From: Zac Denton
Sent: 15 April 2019 08:00
To: Lynnyrd Wolfe
Subject: FW: R/73/19/HH - 29 Tasman Close, Rustington
Attachments: 859-01B 29 Tasman Close Plans and Elevations.pdf; 859-03A 29 Tasman Close Existing and Proposed Part Roof Plans.pdf

From: Phil Brown
Sent: 09 April 2019 14:42
To: Zac Denton
Cc: Planning.Responses
Subject: R/73/19/HH - 29 Tasman Close, Rustington

DWG NO 859/01
REV. B

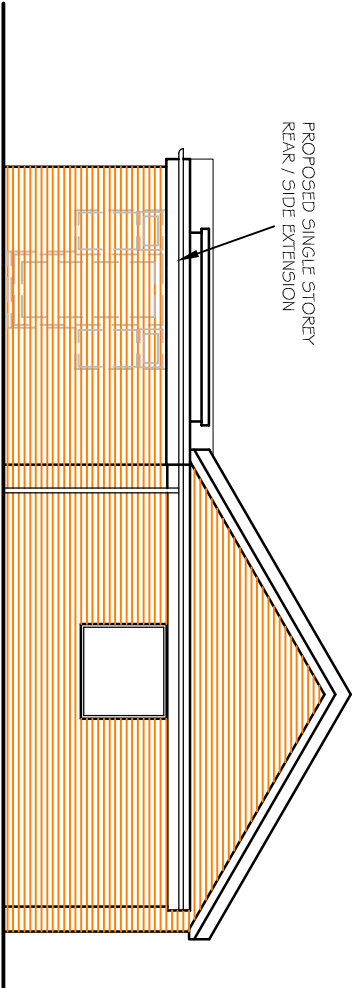
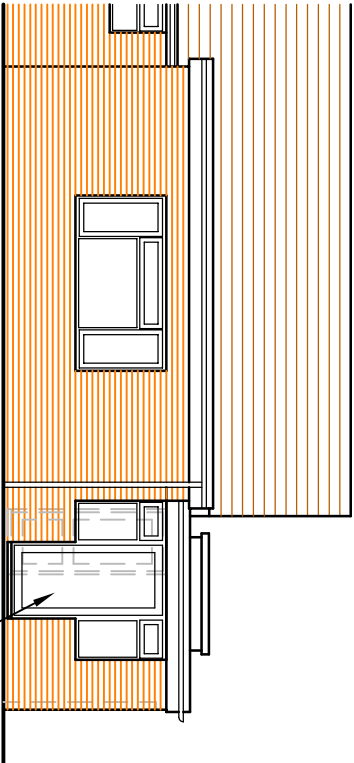
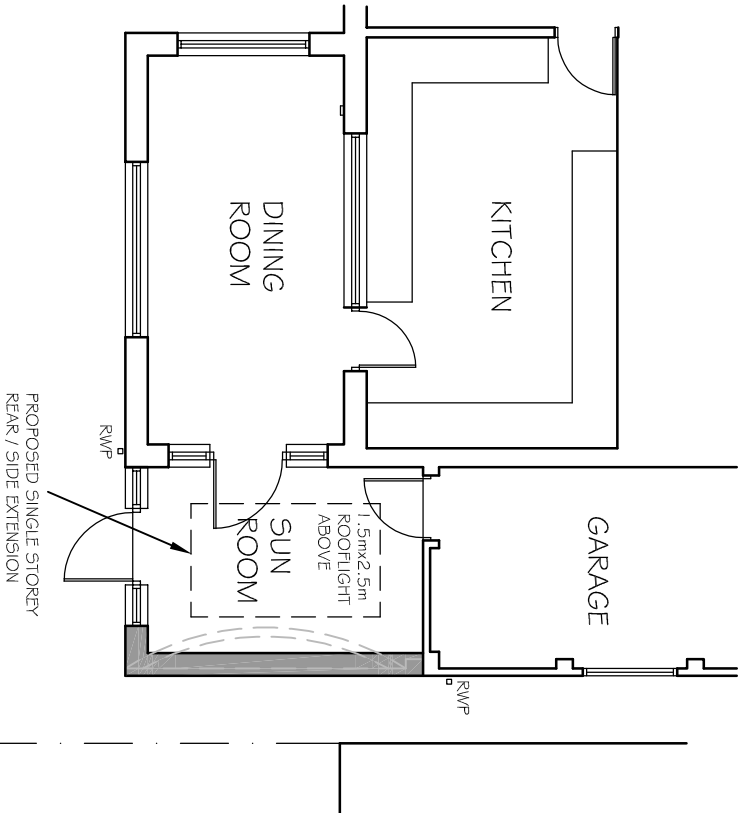
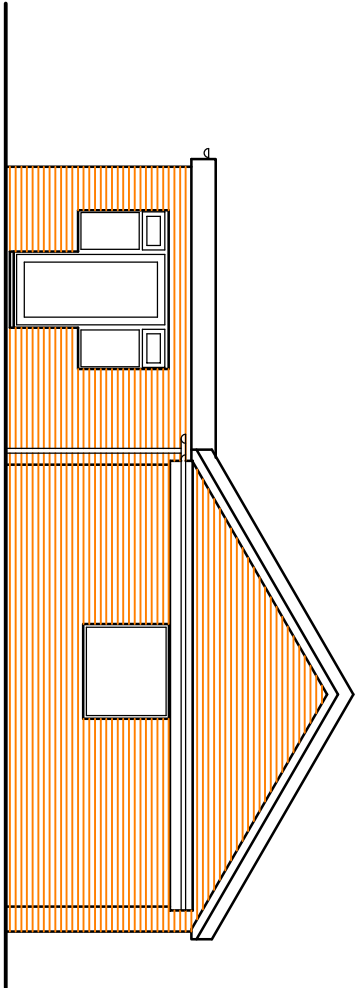
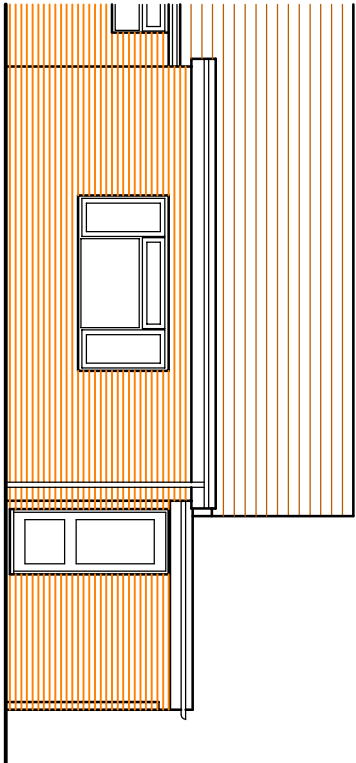
Further to the recent submission of the planning application, please find attached slightly amended proposals which have been made following consultation with the neighbouring owner. The flat roof of the proposed extension has been lowered slightly, and the previously proposed lantern light replaced with a plateau type rooflight. Can you please arrange for these drawings to be substituted for the previously submitted versions.
